# CITY OF ALBUQUERQUE

RE: **Lot 31 Block 6 Unit 18, S.A.D. 228**  
**6543 Pato Rd. NW**  
**Grading and Drainage Plan**  
**Engineers Stamp Date 6-19-17 (D10D003M31)**

Based upon the information provided in your submittal received 6/19/17, this plan is cannot be approved for Grading Permit until the following comments are addressed

Topographic Survey
For Grading and Drainage
Address 6543 Pato Road NW Albuquerque, NM
Lot 31 Block 6, Volcano Cliffs, Unit 18
Albuquerque, Bernalillo County, NM
Book D4 Page 106, 01/19/1971
June 2017

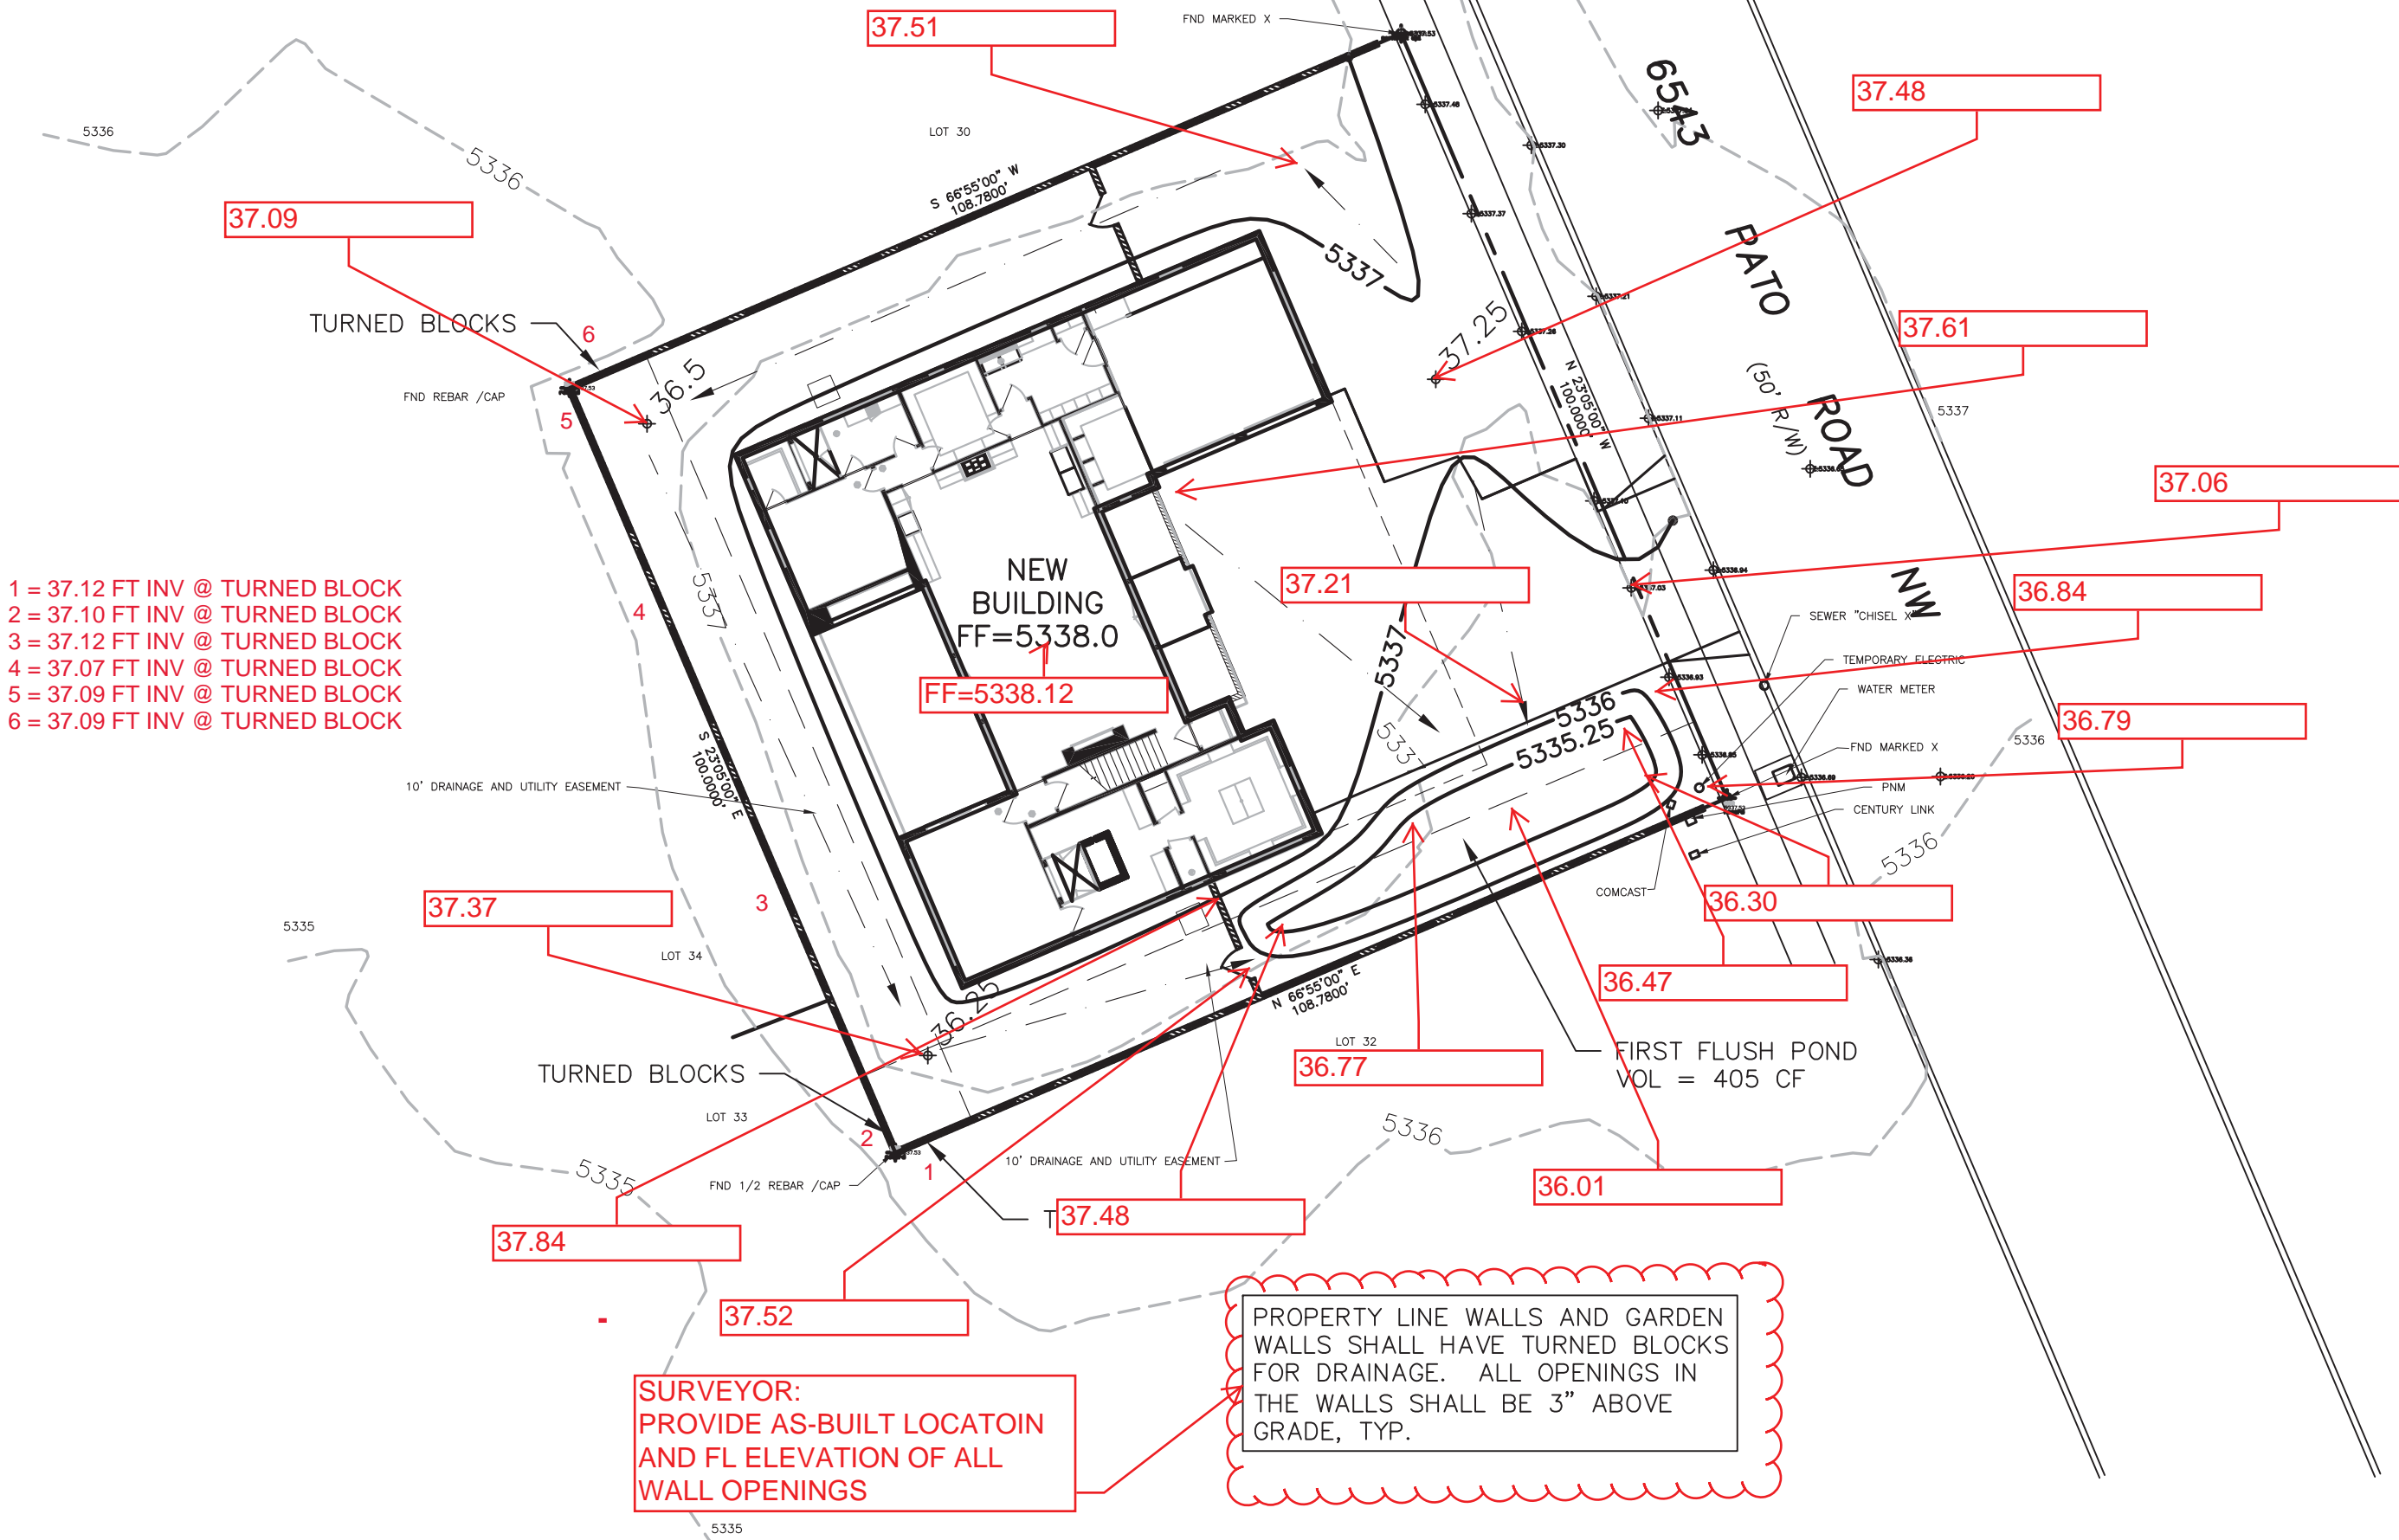
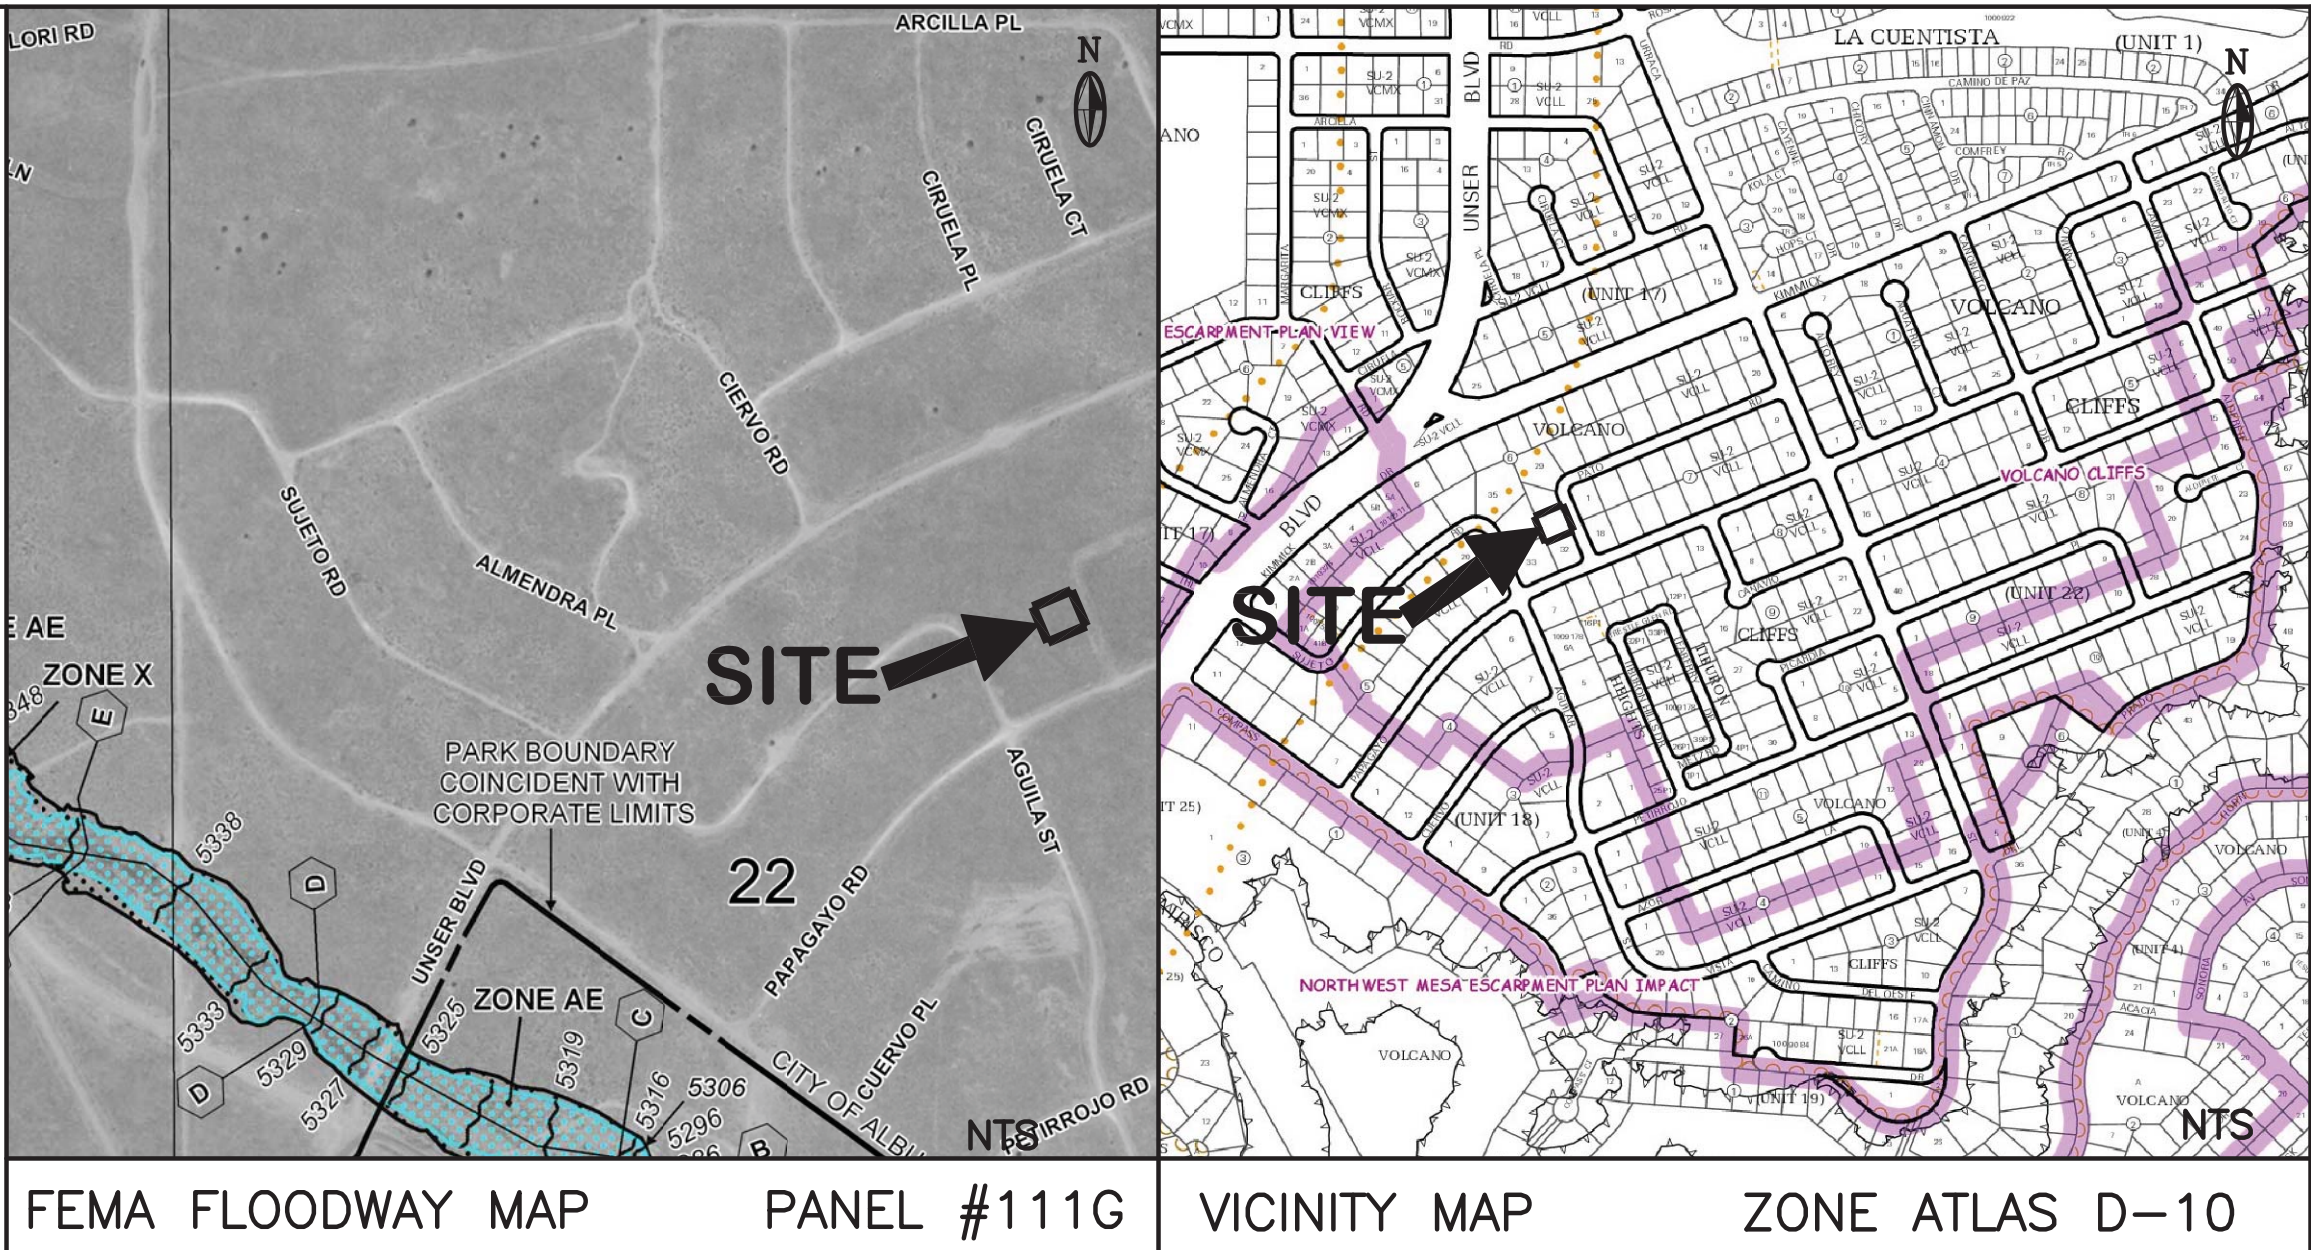
- Provide the calculations for the openings in the North and South rear yard walls for flows heading North to South, as well as the southwest corner rear yard wall for flows heading from east to west.

**The plan has been modified with the added calculations and wall opening note.**
